From: Laura Gibbons [REDACTED]
Sent: 22 September 2020 11:59
To: Michael Eastham <Michael.Eastham@arun.gov.uk>
Cc: Planning.Responses <Planning.Responses@arun.gov.uk>
Subject: Re: FW: A/109/20/RES - Land South of Water Lane, Angmering - Actions for BDW

Overview of applicants response
ADC response 22/09/20

4 TYPICAL SUDS FEATURES

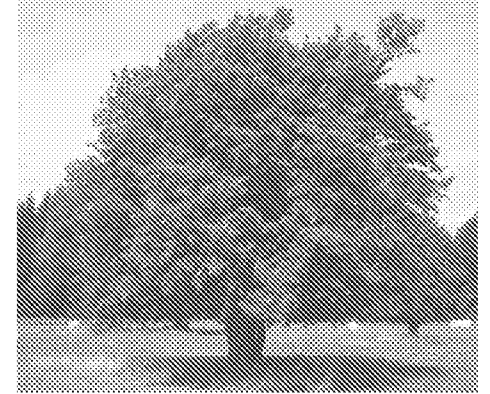
9. Please remove the proposed trees from within basin extents, especially the attenuation basin. Stated that no trees are shown. *Landscape plans clearly show trees within basin extents.*
